A303 Amesbury to Berwick Down

Deadline 2
8.10.2 Agriculture (Ag.1)

Agriculture (Ag.1)

Regulation Number:	Regulation 5(2)(q)
Planning Inspectorate Scheme Reference	TR010025
Application Document Reference	8.10.2
Author:	A303 Amesbury to Berwick Down Project Team, Highways England

Drawing Title
**RIGHTS OF WAY AND ACCESS PLANS
REGULATION 5(2)(k) & 5(2)(o)
SHEET 4 OF 15**

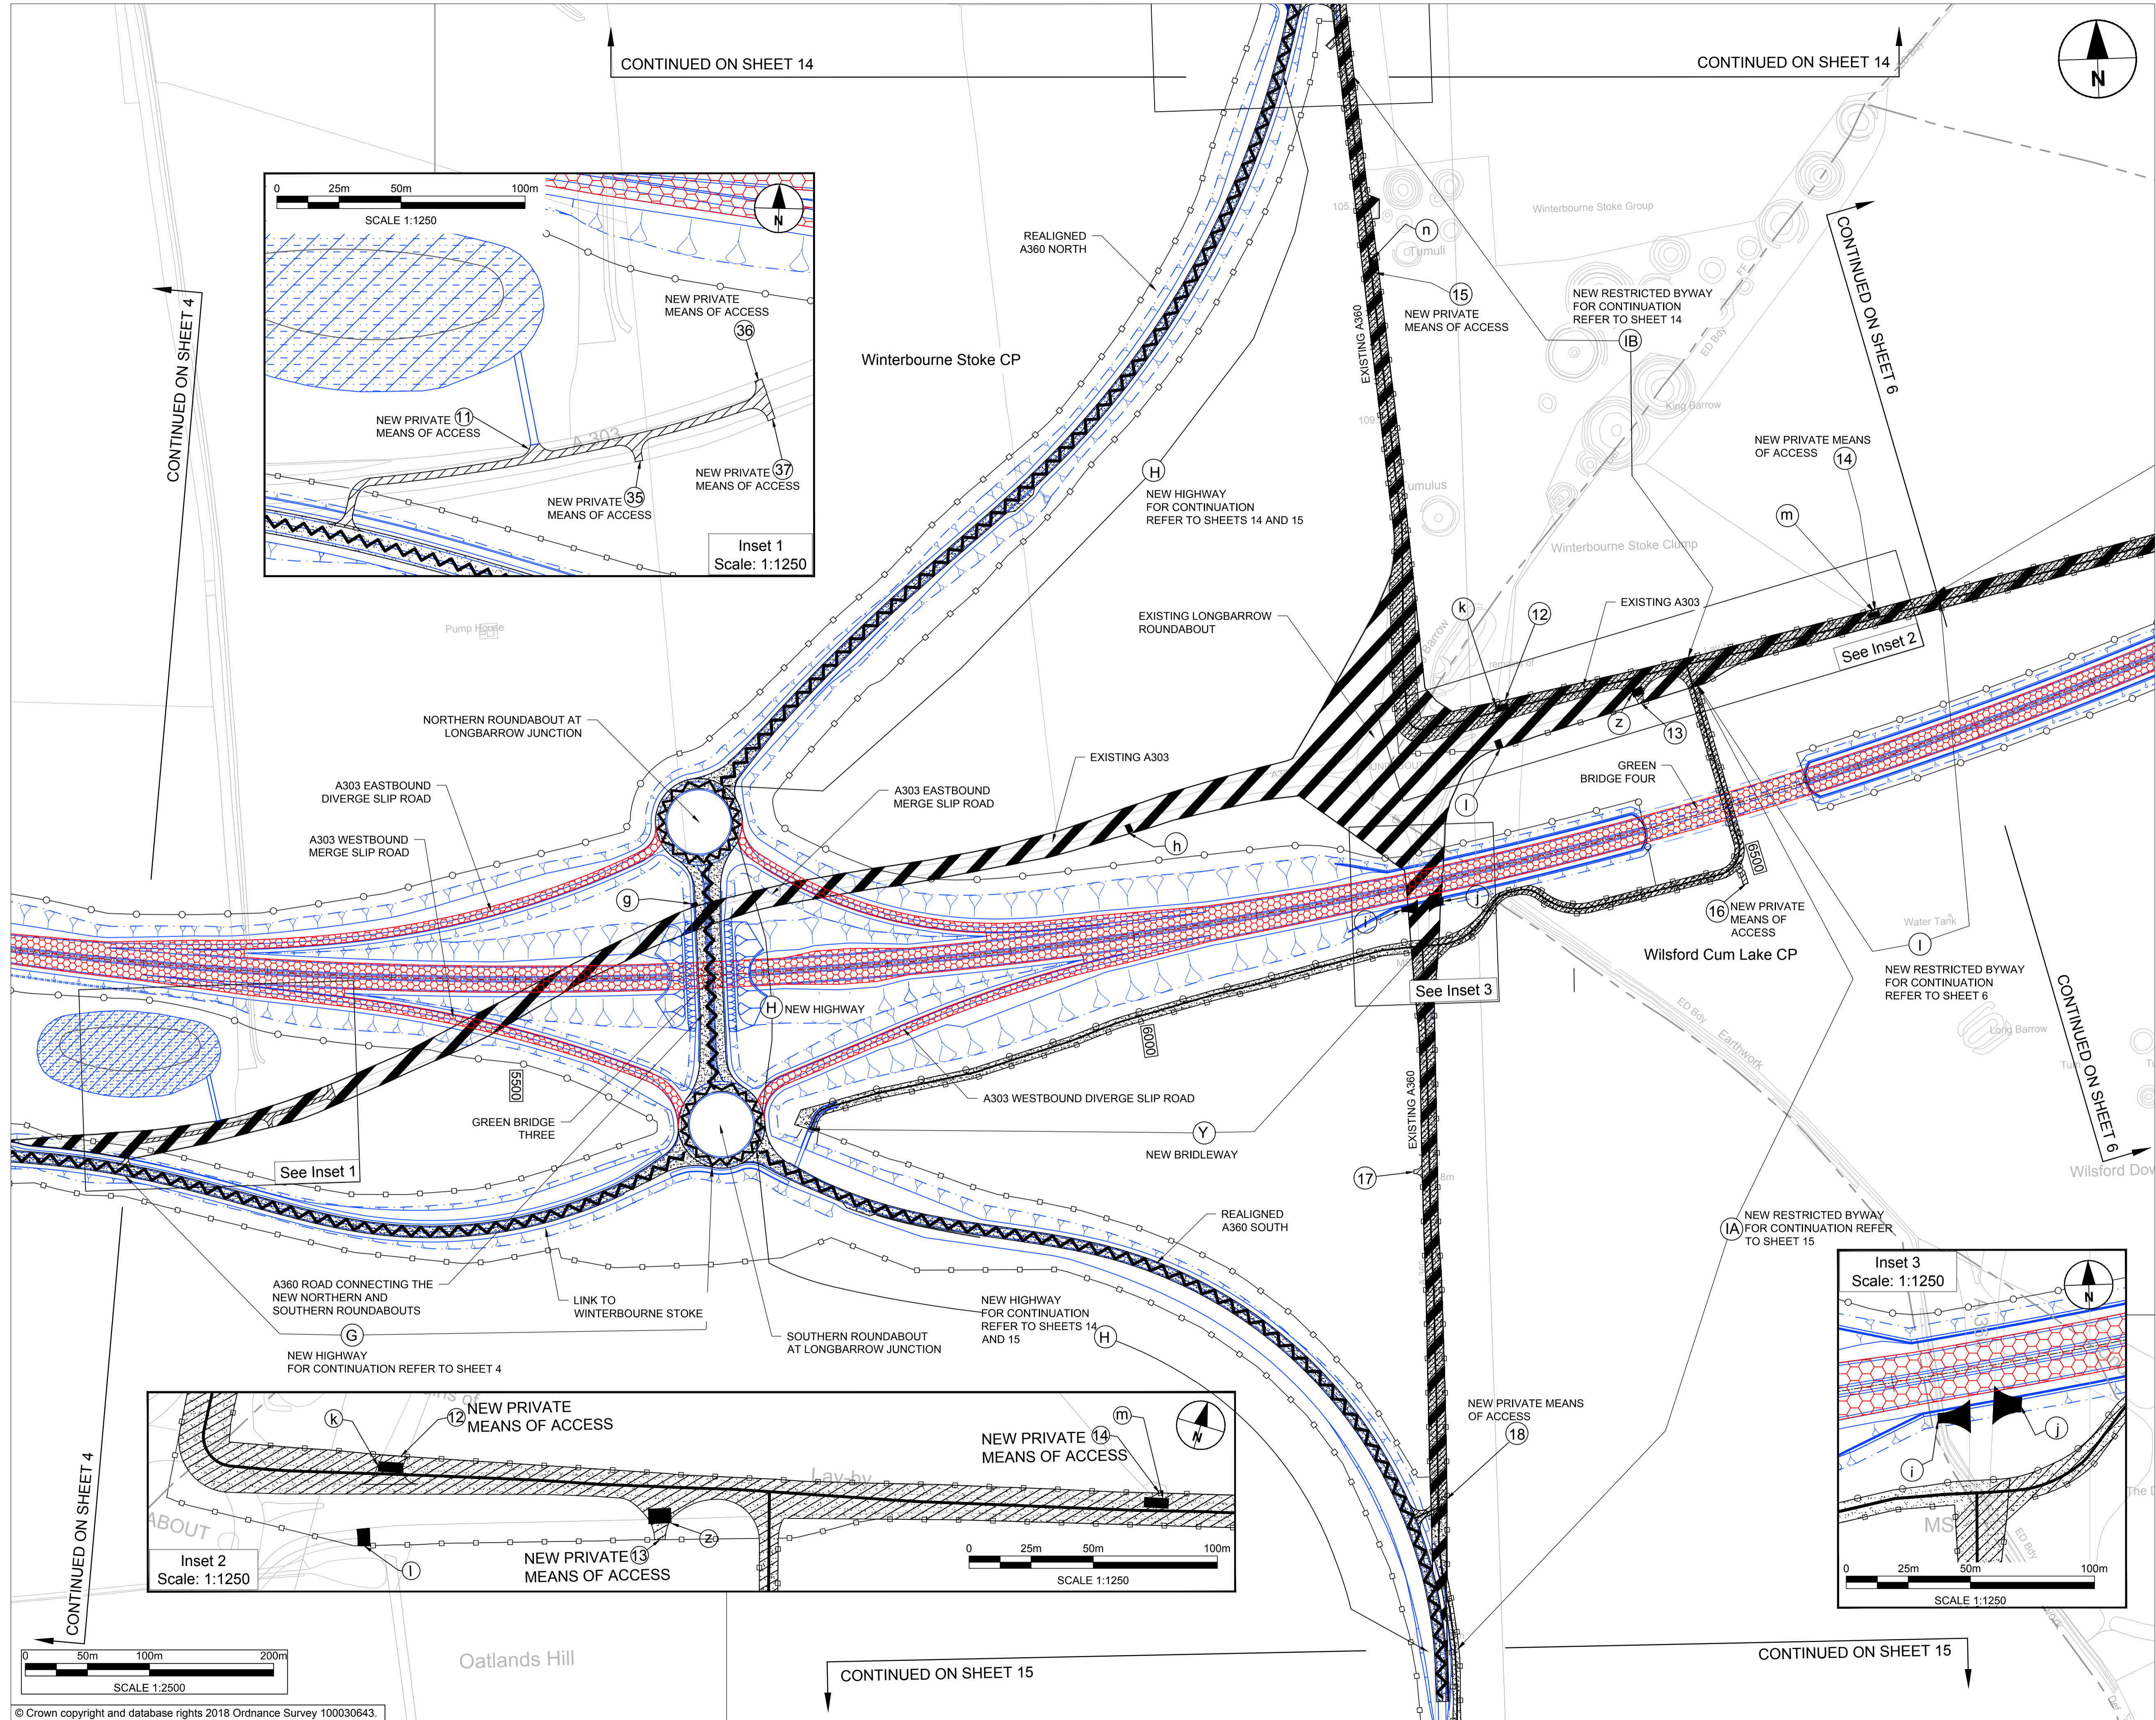
BOAT Reference F (Sheet 4 of the Rights of Way and Access Plans)

14. BOAT Reference F facilitates the continuation of travel along the existing byway, WSTO6B, which would otherwise be severed by the new A303. This route provides a minimal diversion from WSTO6B's original alignment and would require additional agricultural land. This diversion is necessary to provide the elevation difference required to bridge the A303. The diversion also allows the crossing of the A303 perpendicular to the carriageway alignment and therefore spans the shortest distance. It is additionally required to provide a private means of vehicular access to the land to the west of WSTO6B, of which includes access to a proposed drainage pond, reference 10.

Drawing Title
**RIGHTS OF WAY AND ACCESS
PLANS
REGULATION 5(2)(k) & 5(2)(o)
SHEET 5 OF 15**

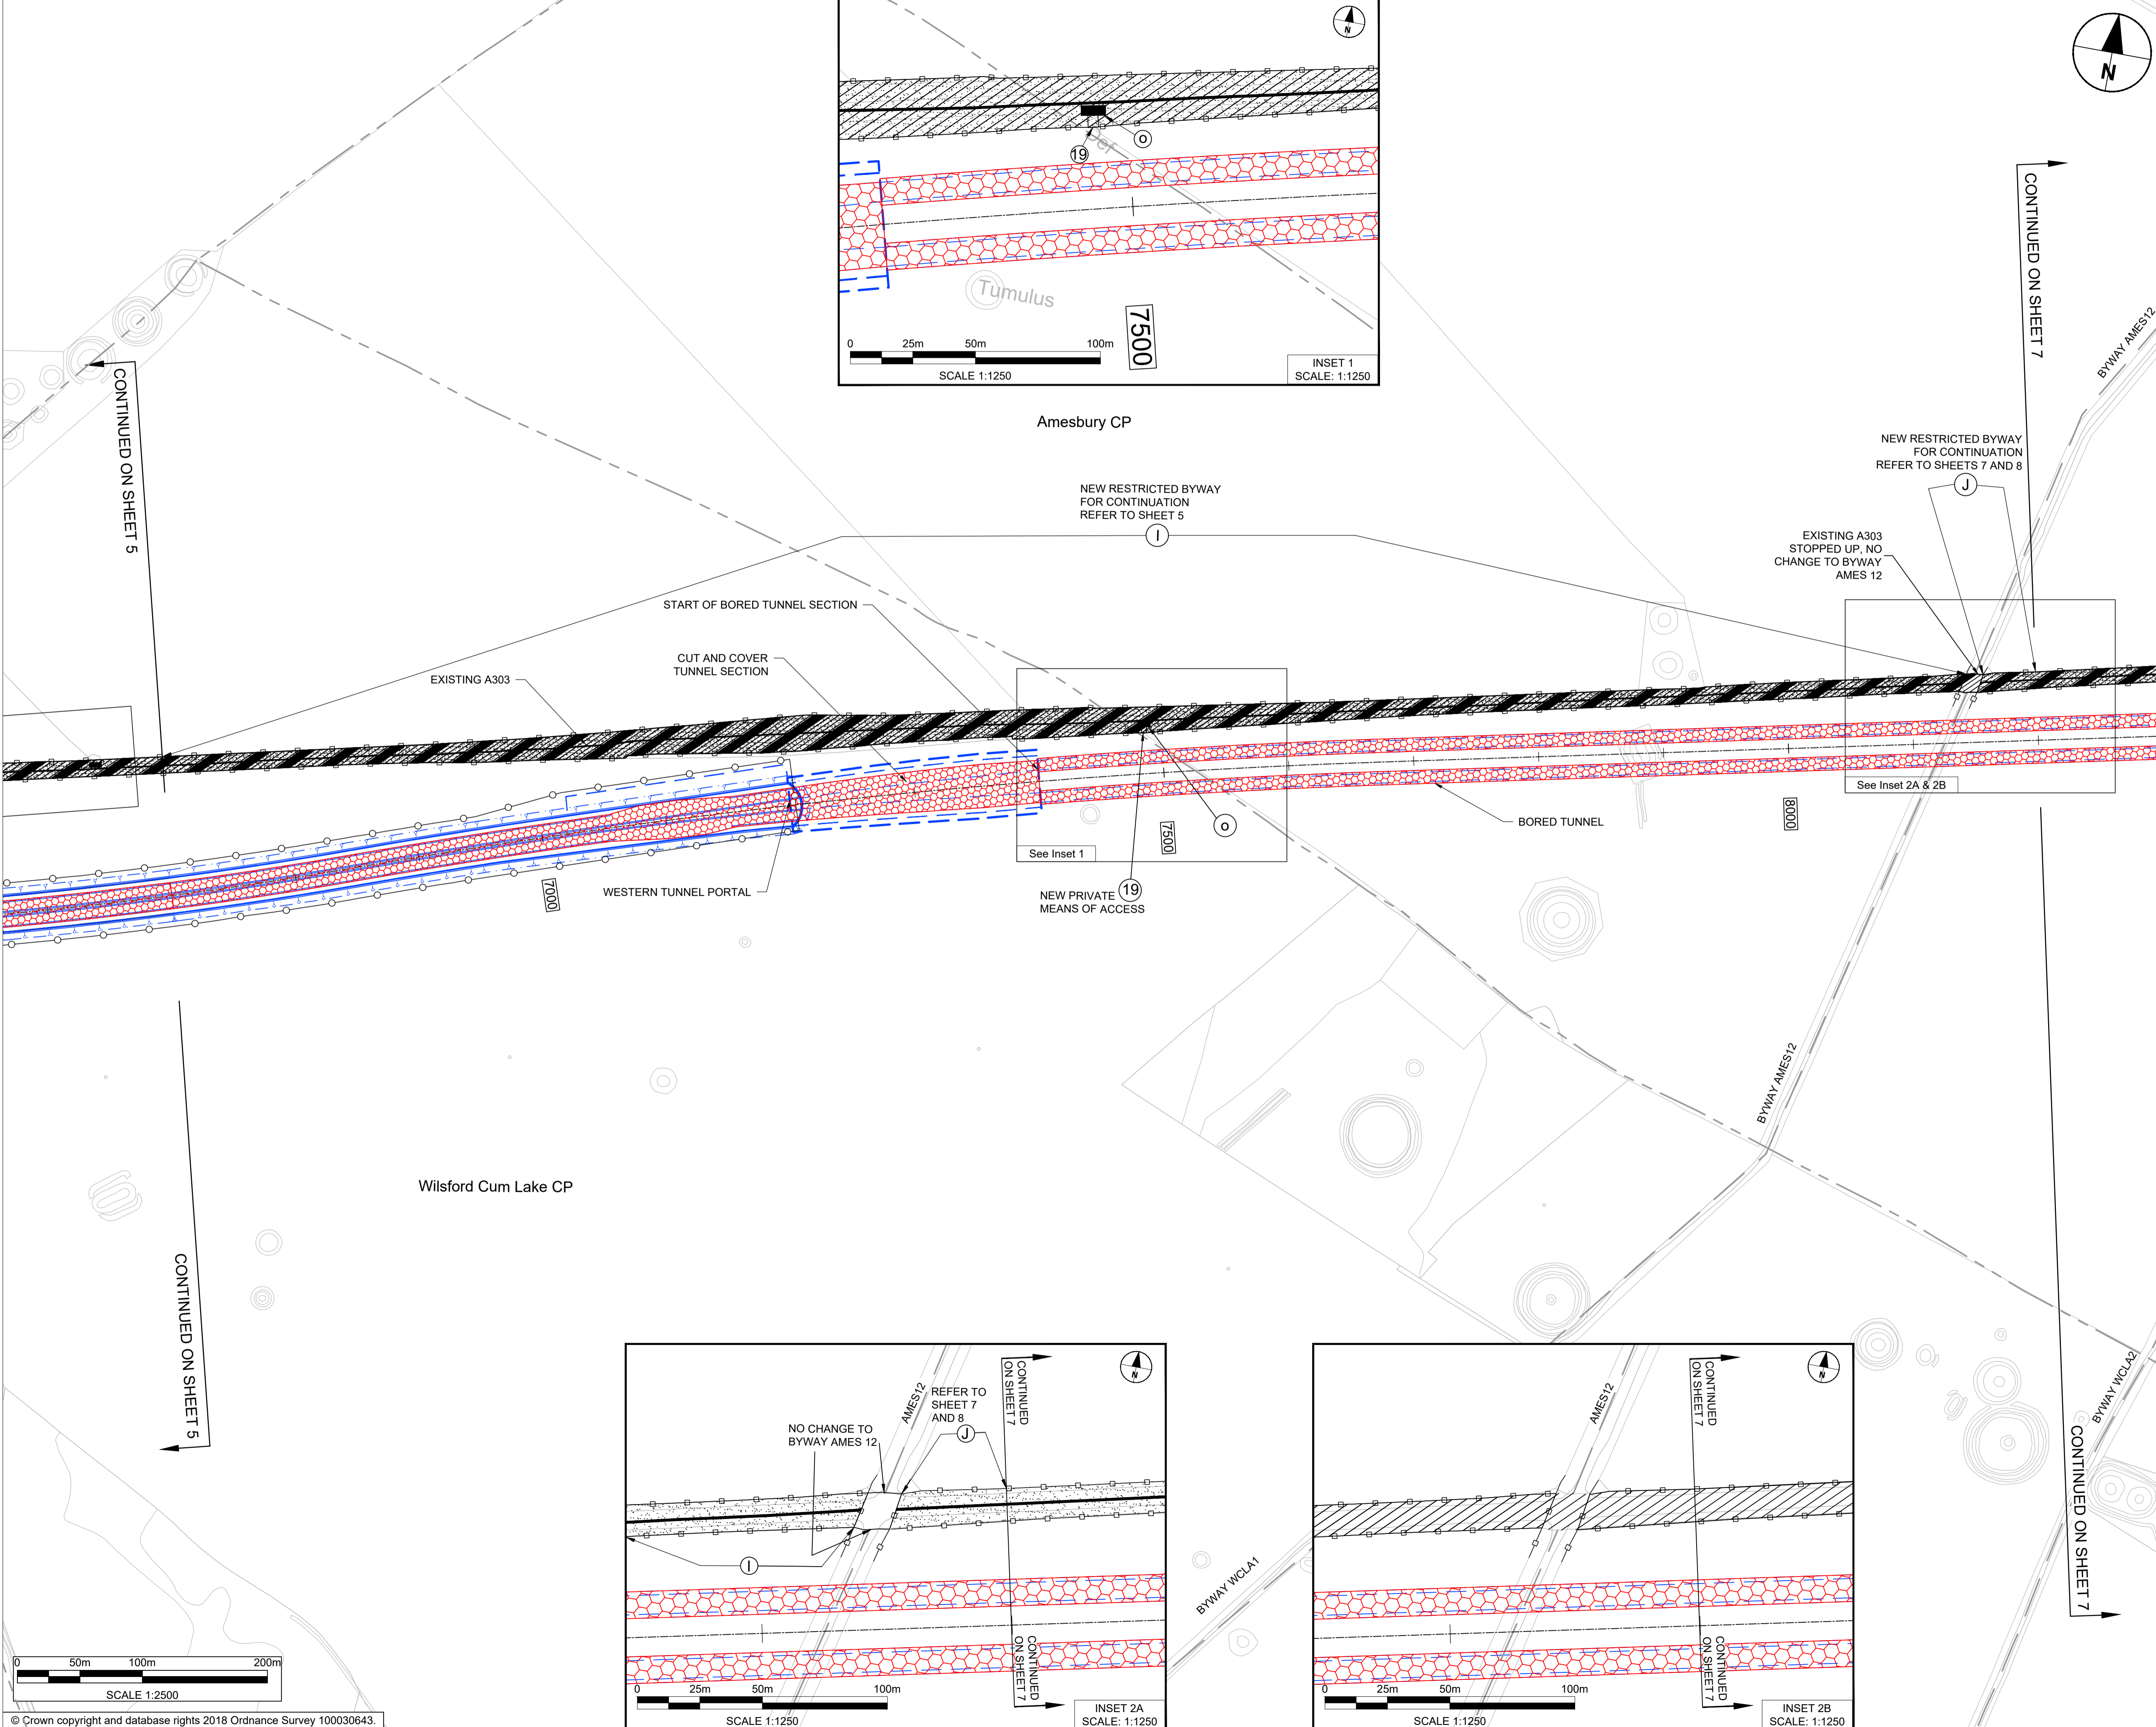
Restricted Byway Reference IA (Sheet 5 and 15 Rights of Way and Access Plans)

Restricted Byways References I, IB, J (Sheets 5, 6, 7 & 8 Rights of Way and Access Plans)

15. Restricted byway, reference IA provides a link between the proposed restricted byway near the existing Longbarrow junction in the north, the existing restricted byway BSJA9 to the west and new bridleway (Bridleway Reference V) to the south. Agricultural land would be required for the length south of the tie-in of the new A360 link to the existing A360. It follows the route of the existing A360 highway to be stopped up, and thus creates no new agricultural severance. It would also serve as a means of vehicular access to agricultural land, references 16, 17, 18. It is carried over the existing A303 by Green Bridge Four.

16. The land required for these restricted byways is comprised within existing highway to be stopped up (parts of the existing A303, A360 and Stonehenge Road) and so do not require agricultural land. These restricted byways would also serve as private means of vehicular access to agricultural land, necessitated by the stopping up of the existing A303 within the WHS and the provision of the new Longbarrow Junction, references 12, 13, 14, 15, 19, 20, 21, 22, 23, 24, 25, 26 and 27.
